From: Ian Hayward [REDACTED]
Sent: 04 May 2018 15:02
To: Simon Davis
Subject: RE: AL/136/17/PL Fontwell Avenue

A revised plan CHI/17089/P has been provided.

PROPOSED SITE PLAN 1:200

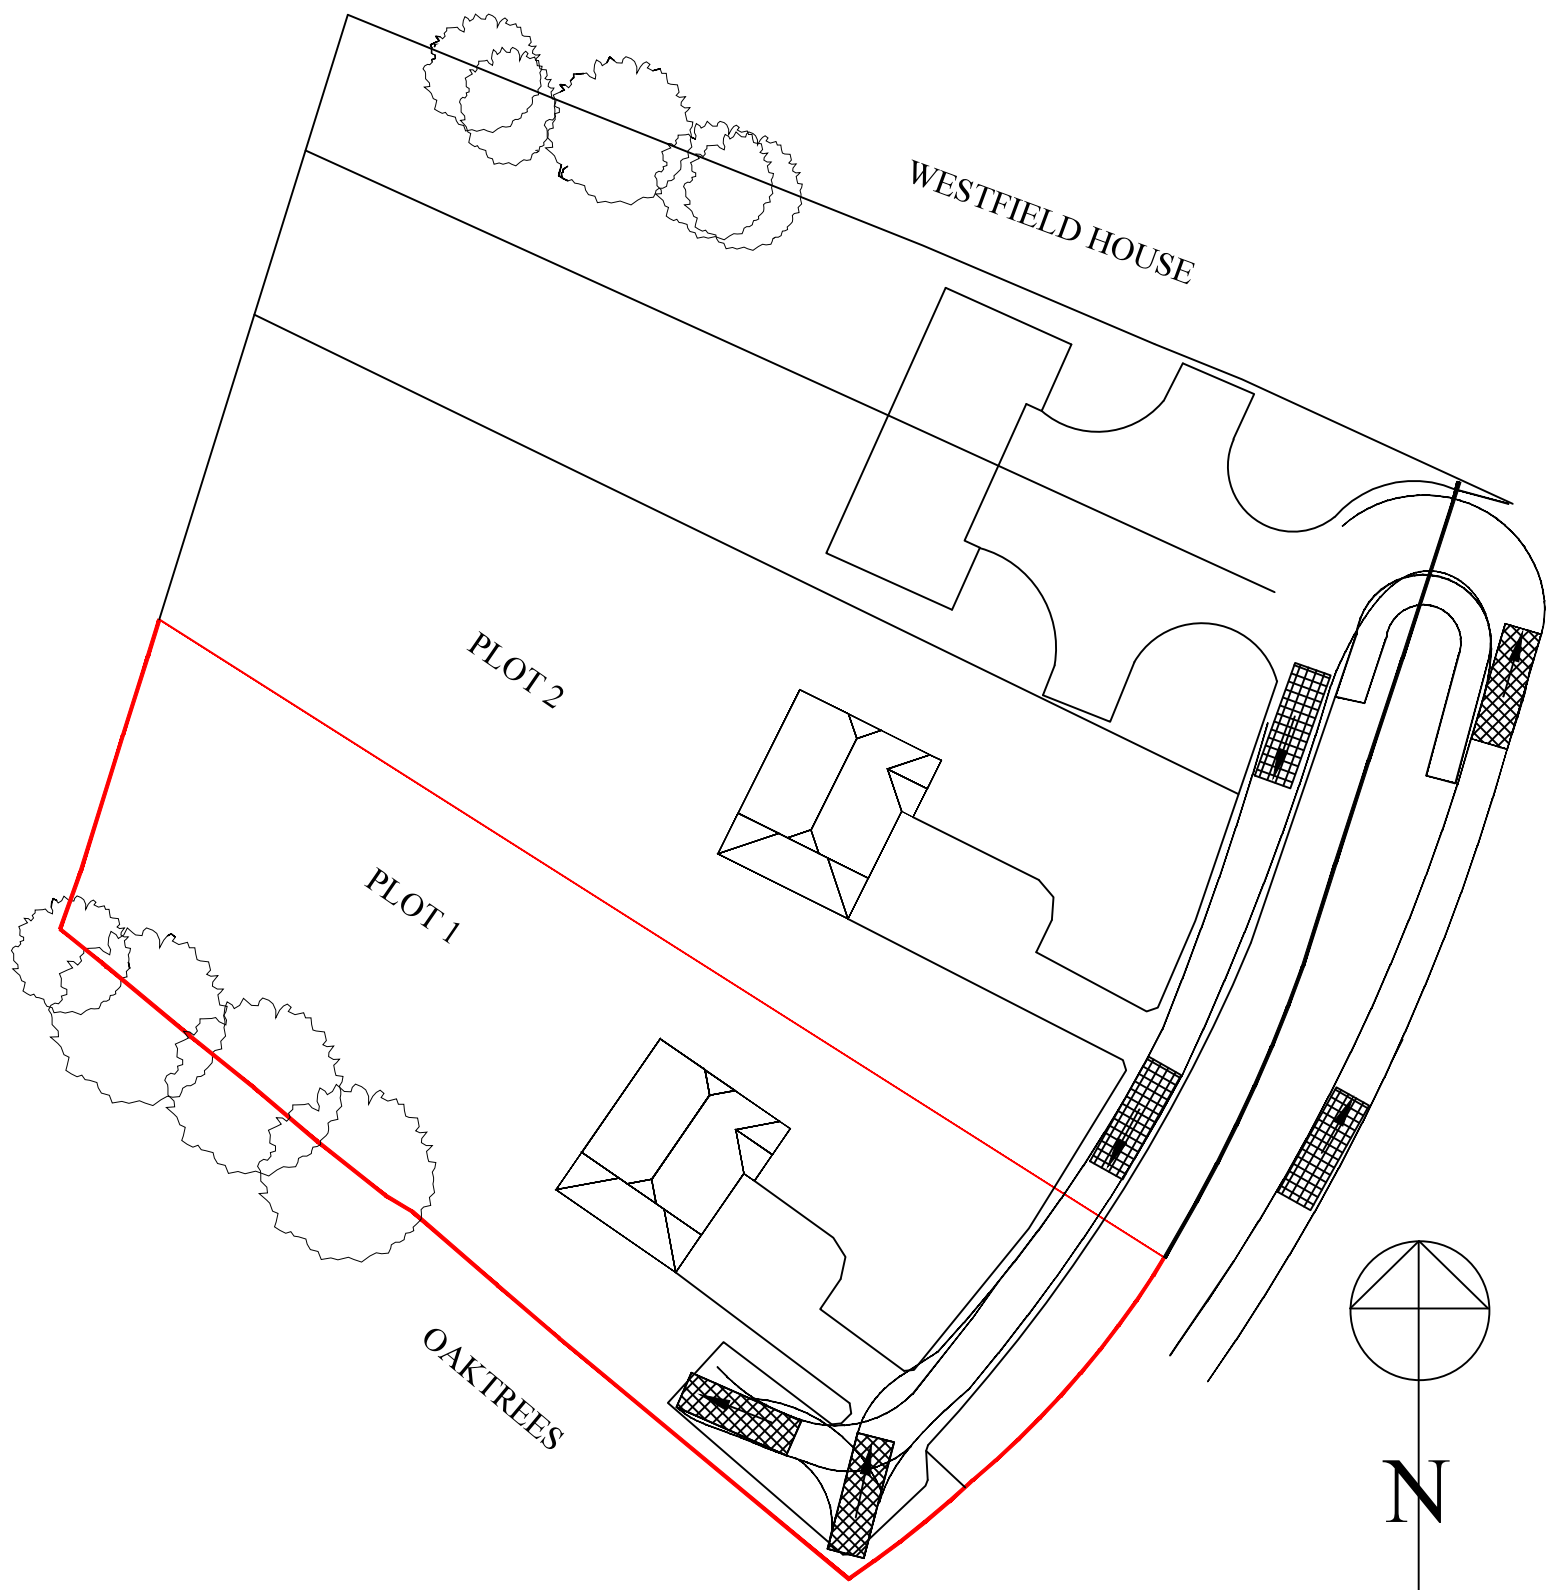
I note a 2.4 x 63 metre visibility splay has been annotated on the proposed site plan. This is greater than the minimum 59 metres splay as calculated using Manual for Streets Stopping Sight Distance calculation coefficients based upon the historic speed survey data of (37.1 mph 85th percentile approach speed).

However this splay has still been drawn to the opposing side of Fontwell Avenue, the splay should be drawn to the nearside carriageway edge, or with an offset of 1.0 metres, in line with current guidance and standards within Manual for Streets.

While vehicle tracking has been provided at the proposed southern access point it does not show how the vehicle large emergency / service vehicles will then access the internal access arrangements.

I know I have previously spoken with the applicant before but please reiterate if they needs to speak on the phone or email to go over our requirements to please contact me again. The splays need to be drawn correct to ascertain if they are achievable and to establish to what extent (if any) they will require land fronting plots 2 and 3.
